THE GARDENS AT NORTH CAREFREE

PRE DEVELOPMENT GRADING AND EROSION CONTROL PLAN

EL PASO COUNTY, STATE OF COLORADO

THE GARDENS AT NORTH CAREFREE GRADING AND EROSION CONTROL PLAN EL PASO COUNTY, STATE OF COLORADO

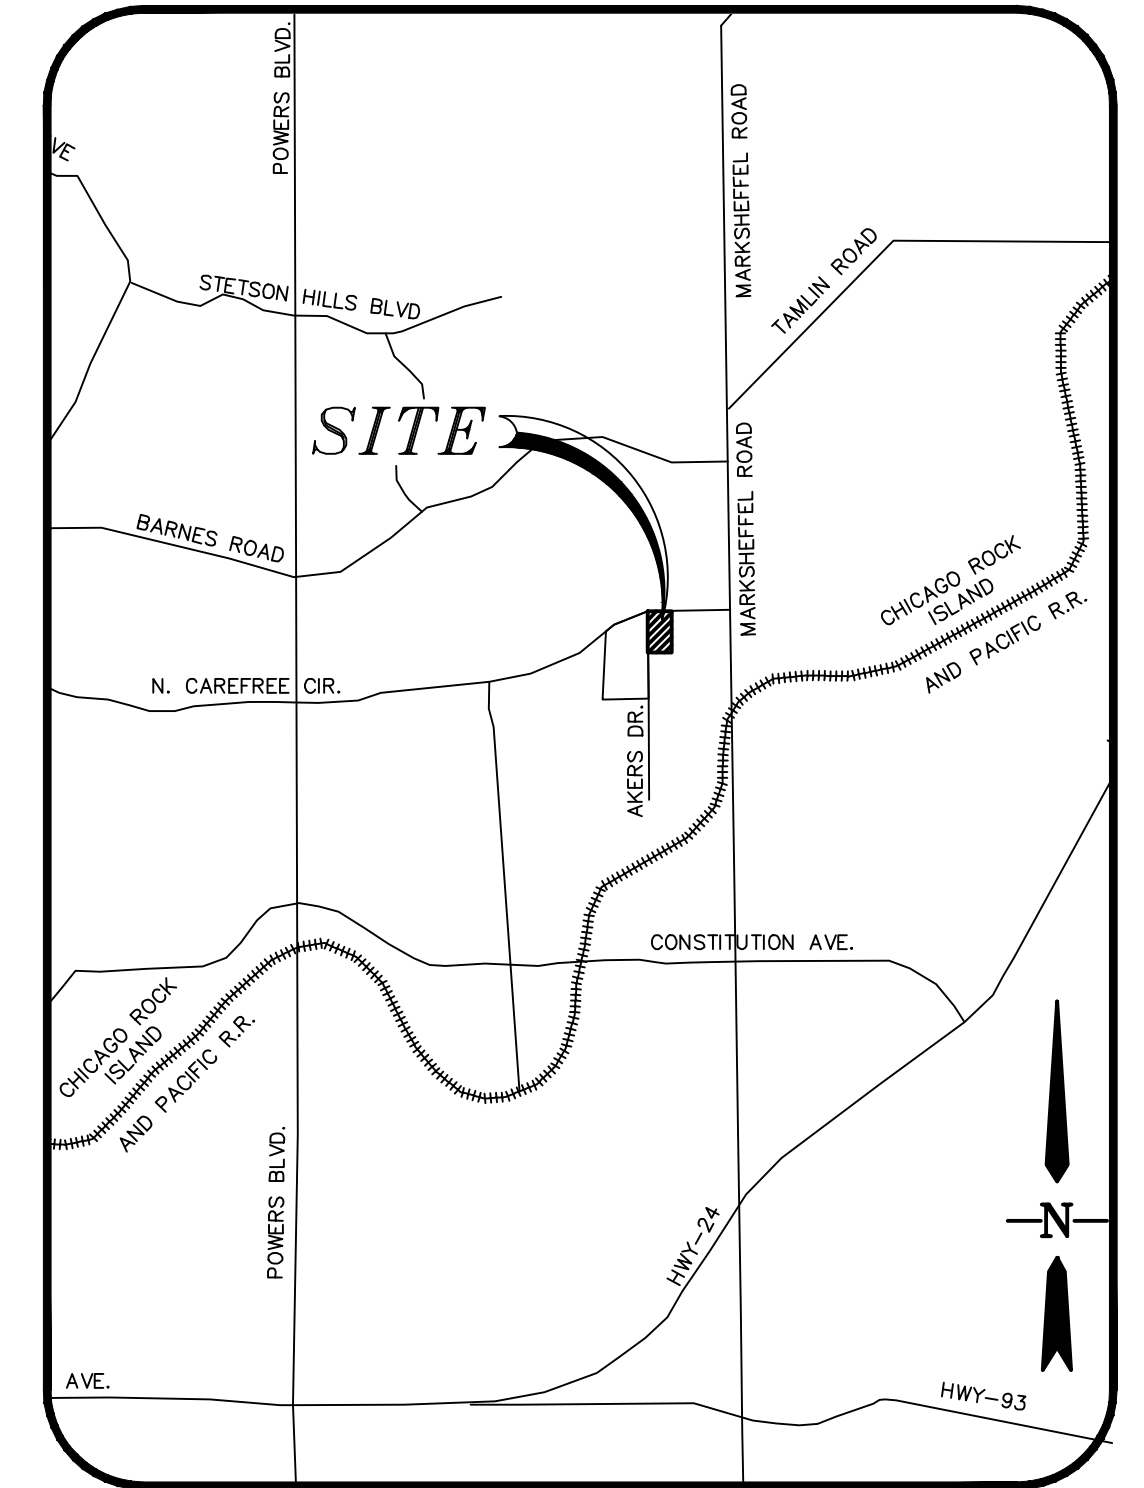
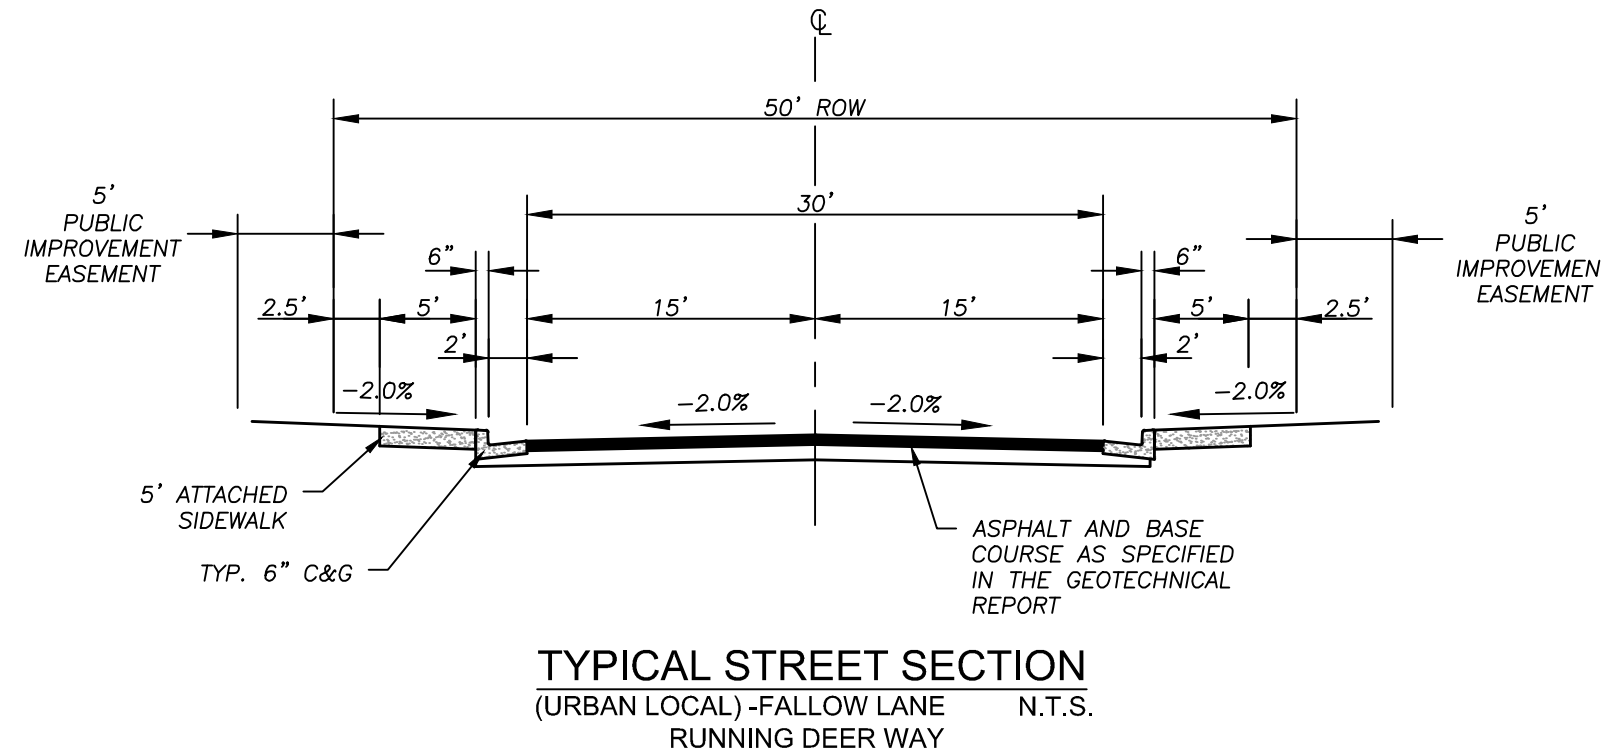
The construction drawings show a 10' public improvements easement. Coordinate all drawings including the plat and revise accordingly.

update the density and number of lots

zoning has already been approved. please update

Revise title. Predevelopment GEC was approved with the PUDSP

THE GARDENS AT NORTH CAREFREE
 GRADING & EROSION CONTROL PLAN

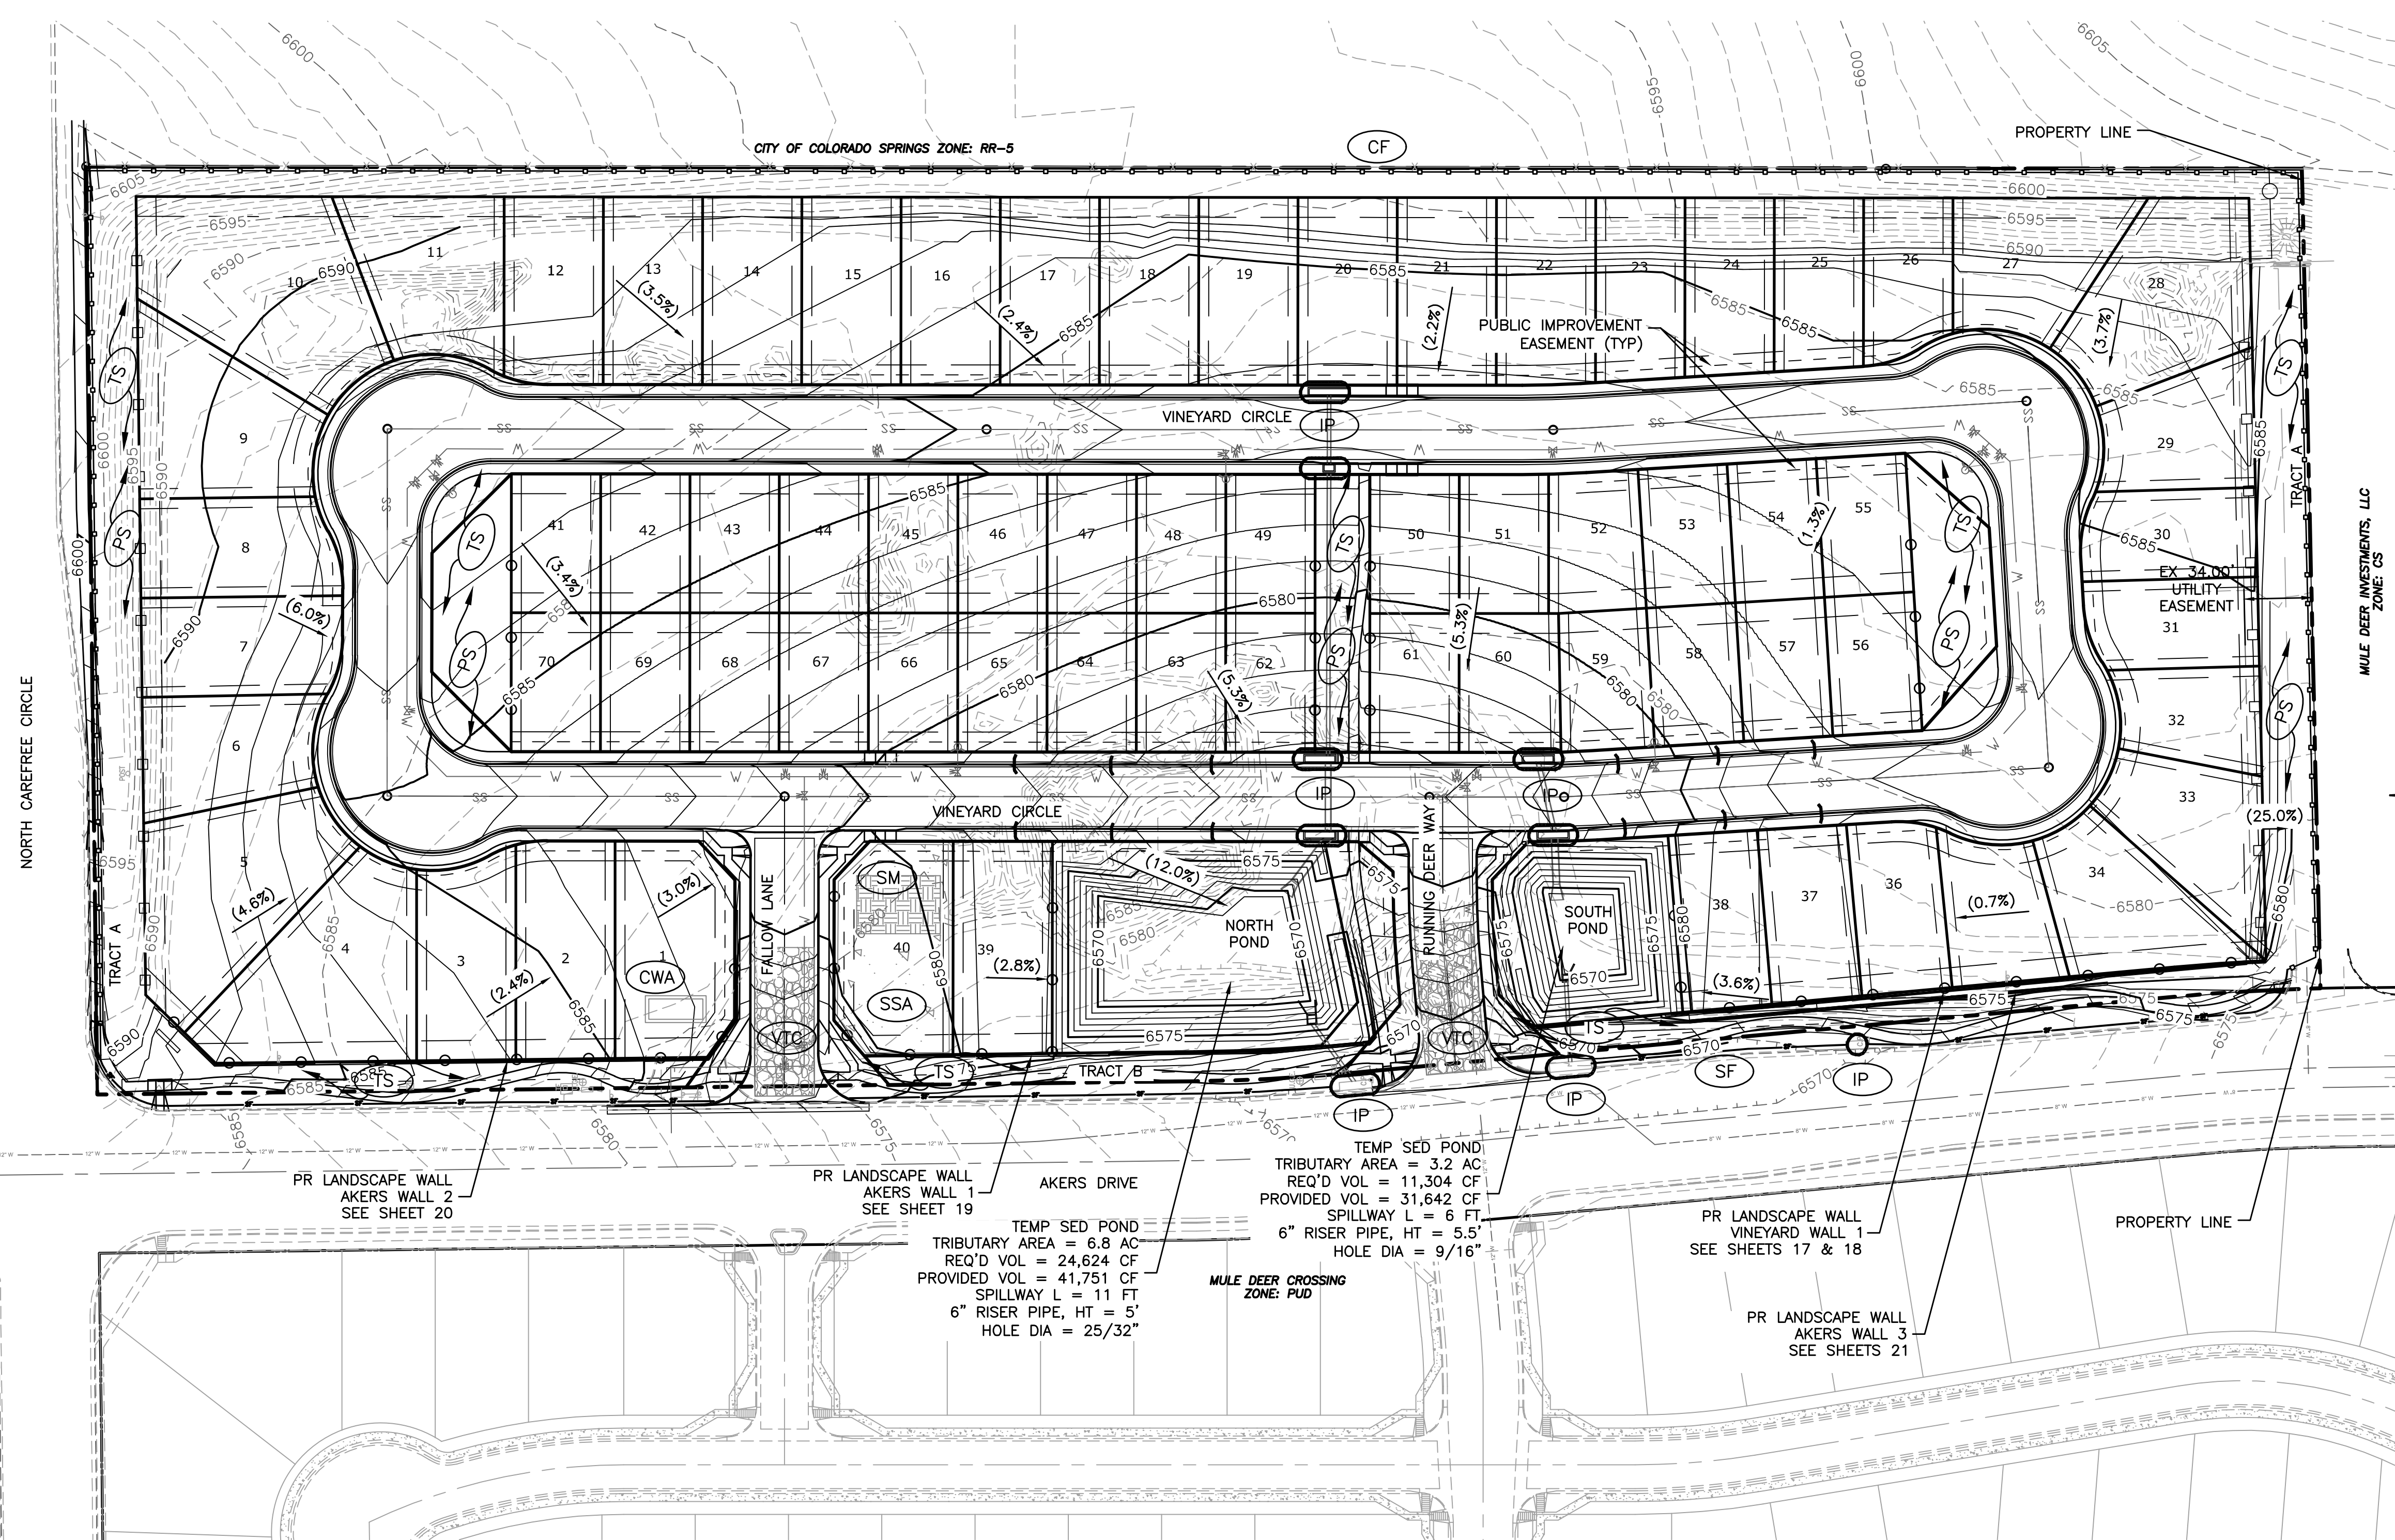
Review 1 comment: Show all existing and proposed easements
 Review 2: Unresolved.

-Provide a note regarding existing vegetation (Item 1.1 on GEC checklist)
